Section 96A of the Town & Country Planning Act 1990 (as amended)
Town and Country Planning (Development Management Procedure) (England) Order 2010 (as amended) - Article 9

Application for a non-material amendment following a grant of planning permission AB/163/14/HH
- to provide additional floor area
11 Priory Road, Arundel, ,

PROJECT			
Proposed extension and alterations to 11 Priory Road, Arundel			
SUBJECT			
Proposed Plans and Elevations			
SCALE 1:100	DATE	DRAWING No 2014 / 37 / 02	Rev A
DRAWN	CHECKED

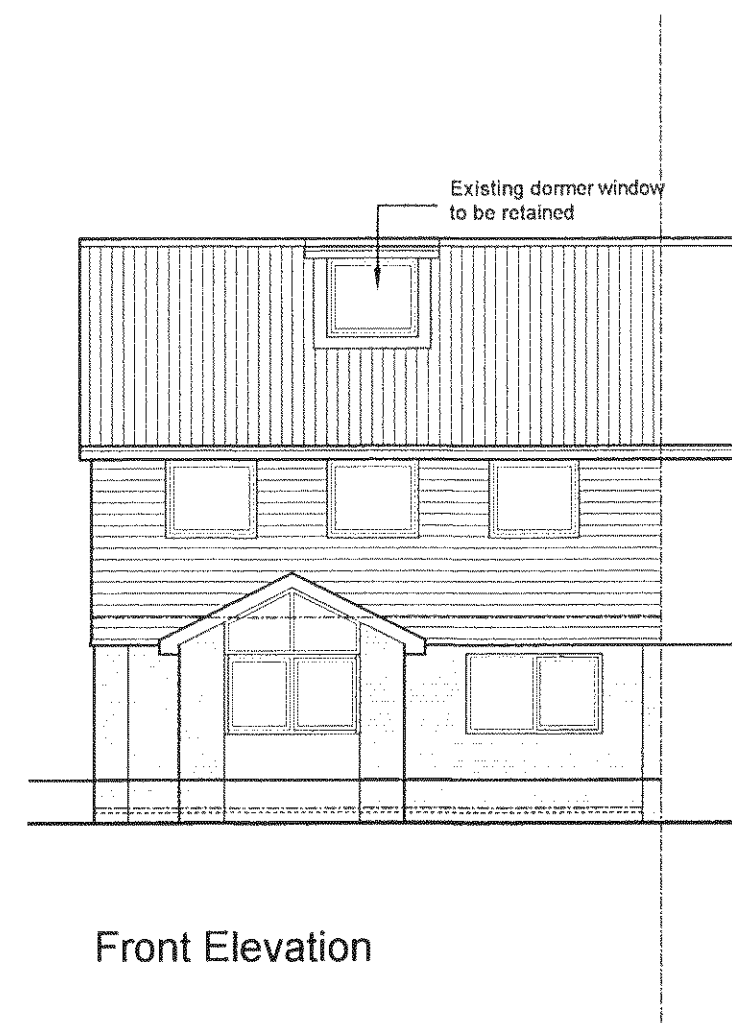
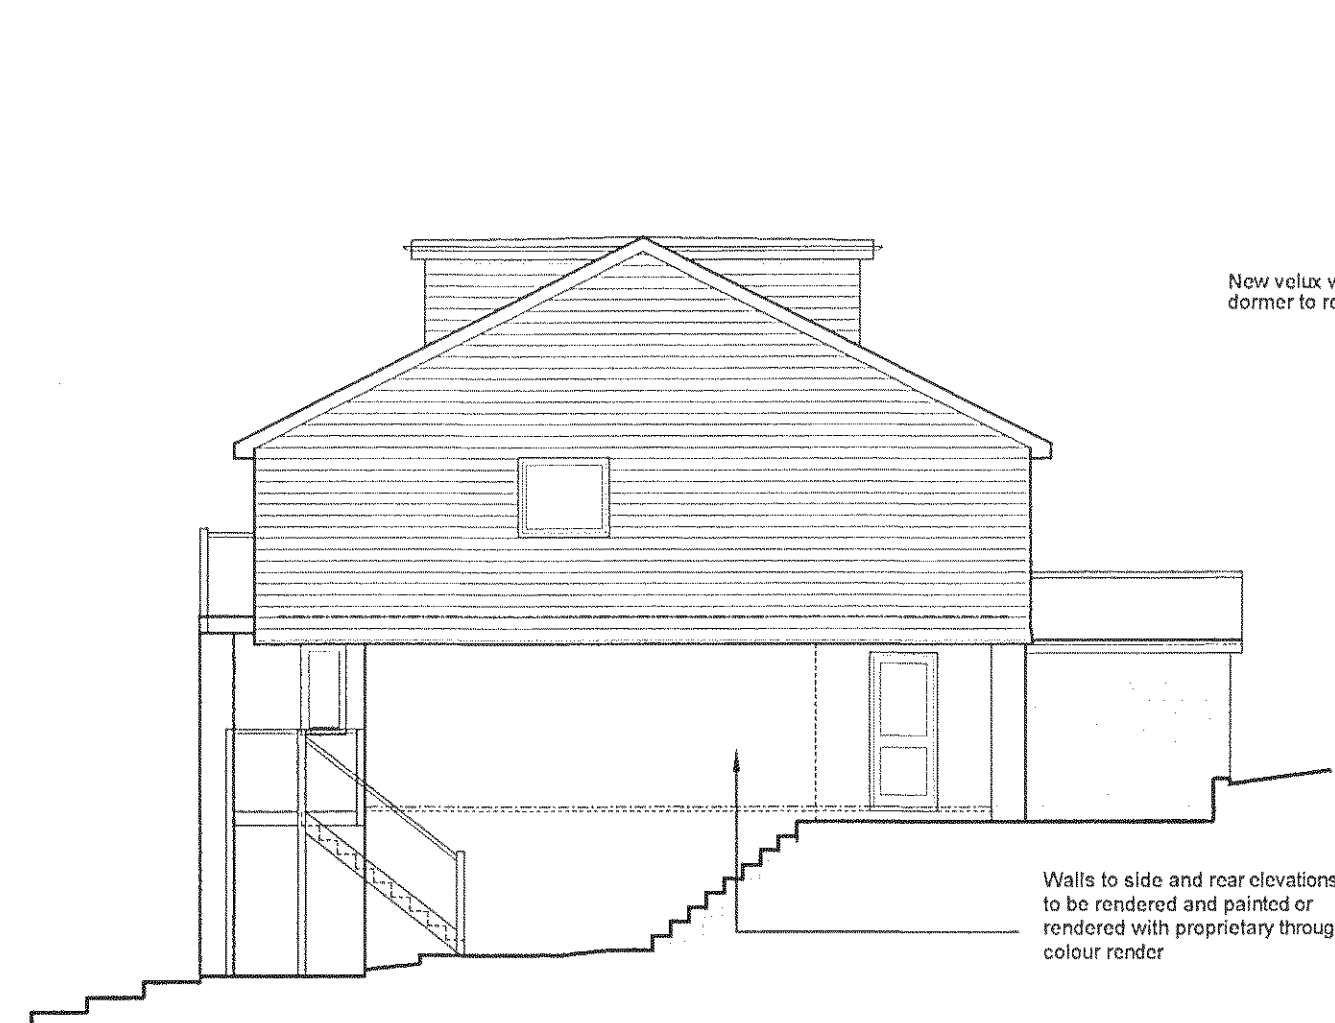
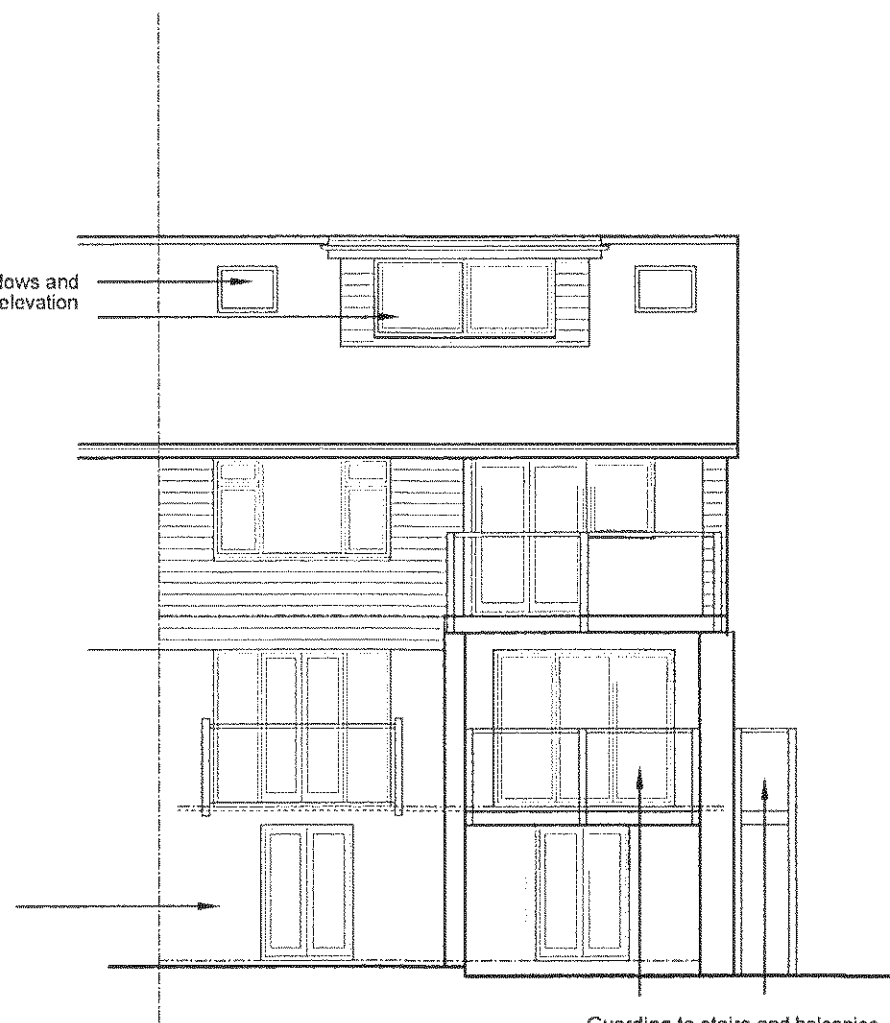
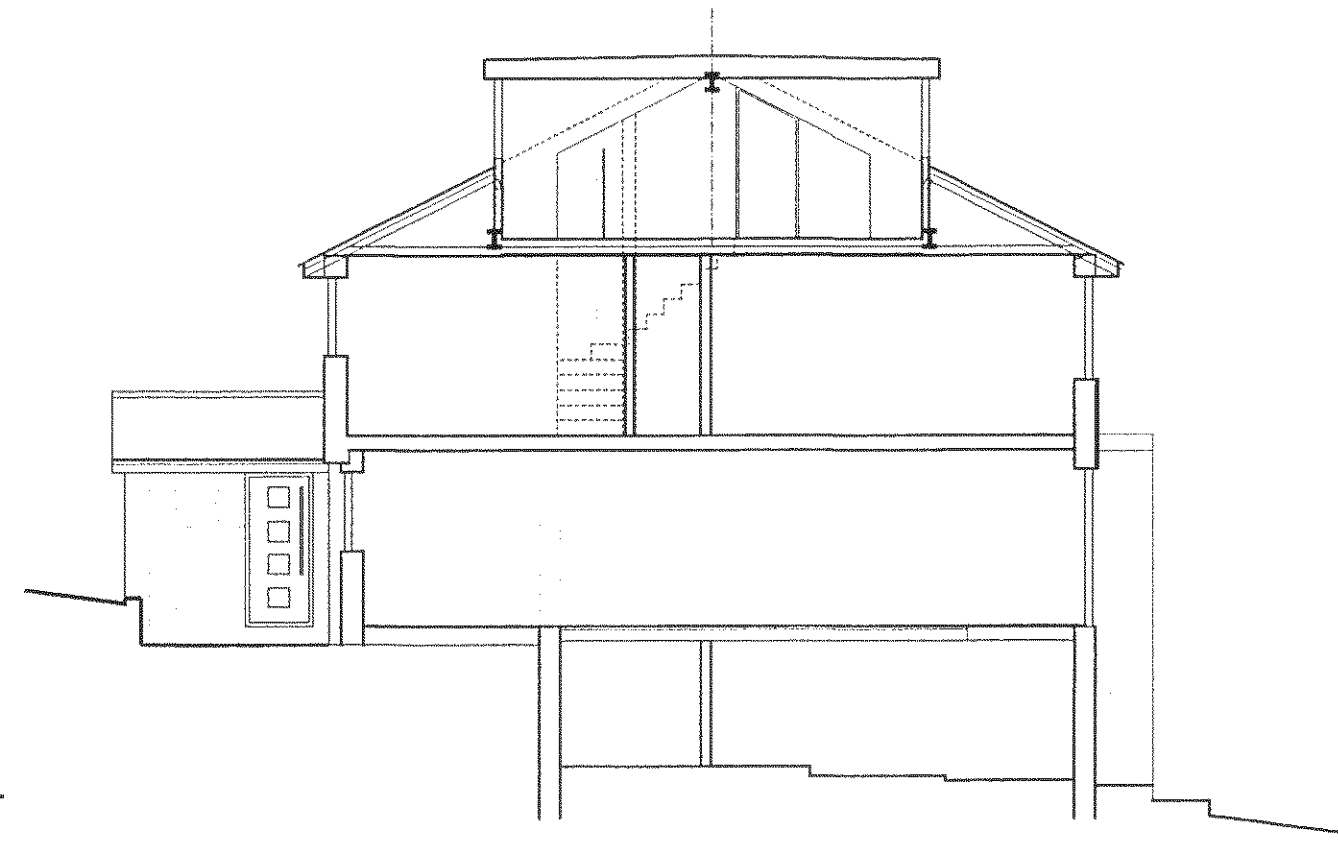
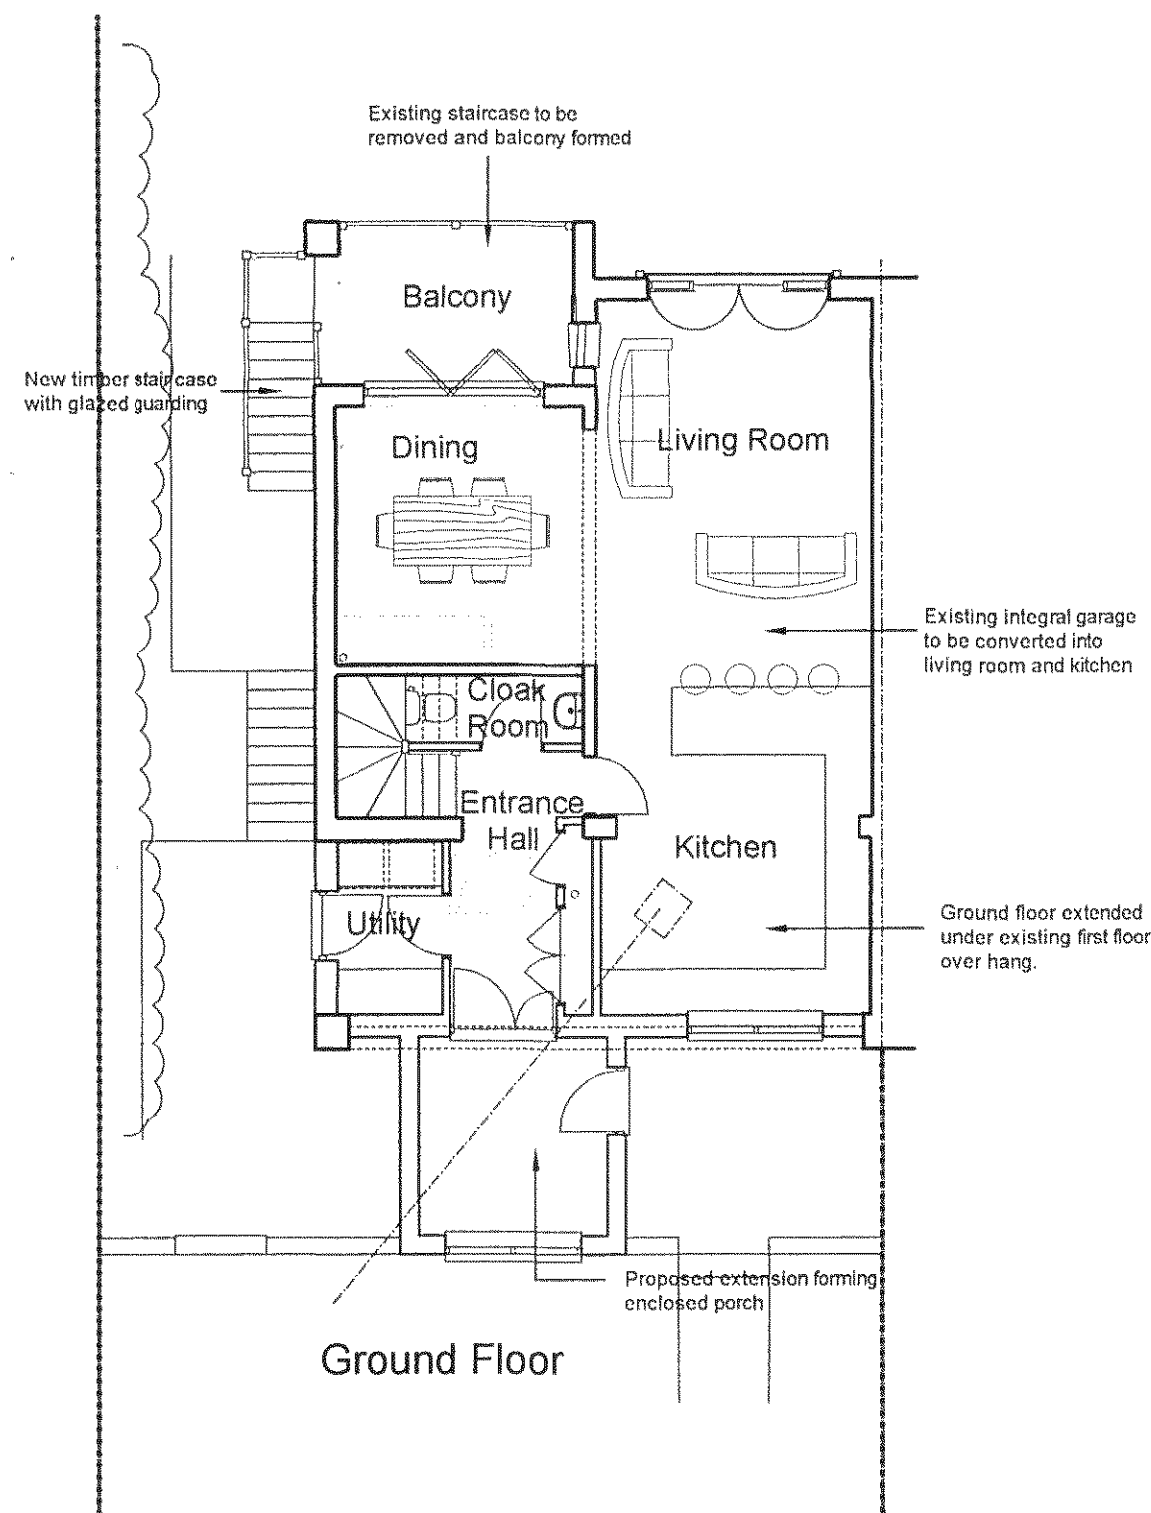
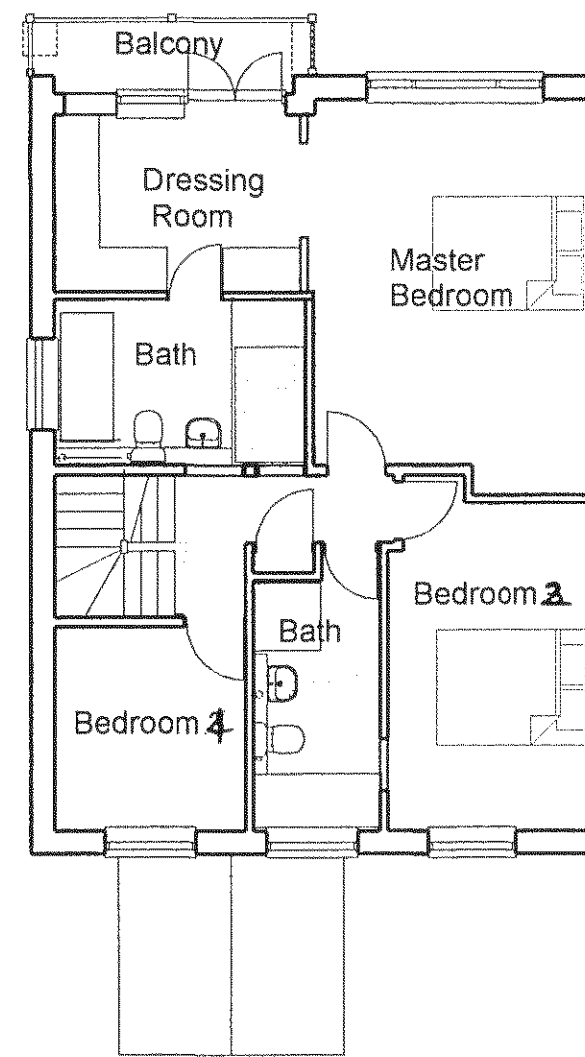
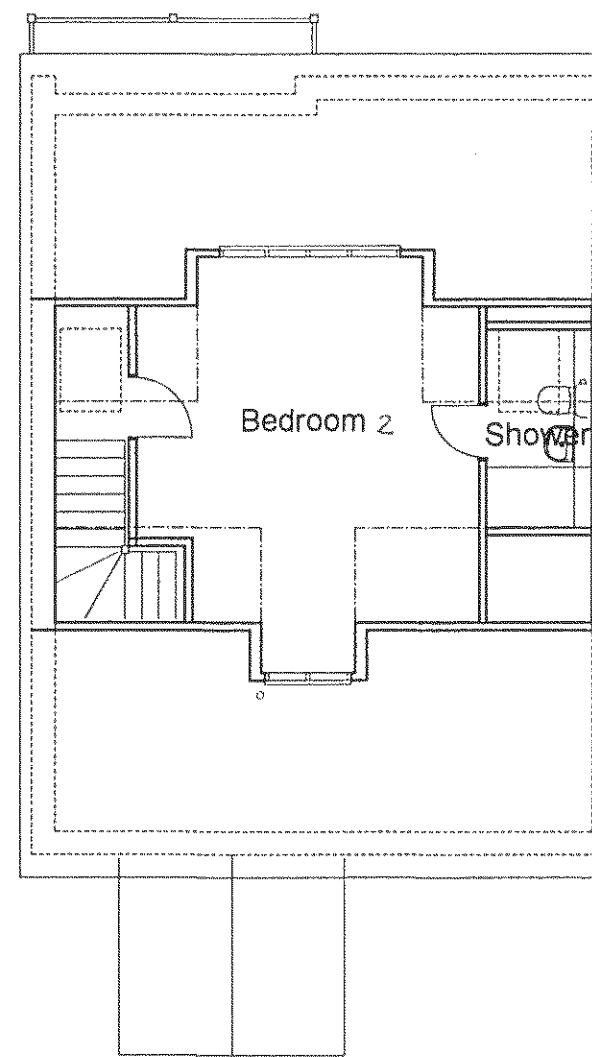
I refer to your recent application for a Non Material Minor Amendment. From the information submitted I am able to take the alterations comprising an extension of the proposed porch by 1m forward, increasing the width of the rear dormer by 500mm and adding an additional velux roof window to the rear elevation. As such the approved plans will now be drawing no. 2014/37/03 Rev A & 2014/37/02 Rev A.
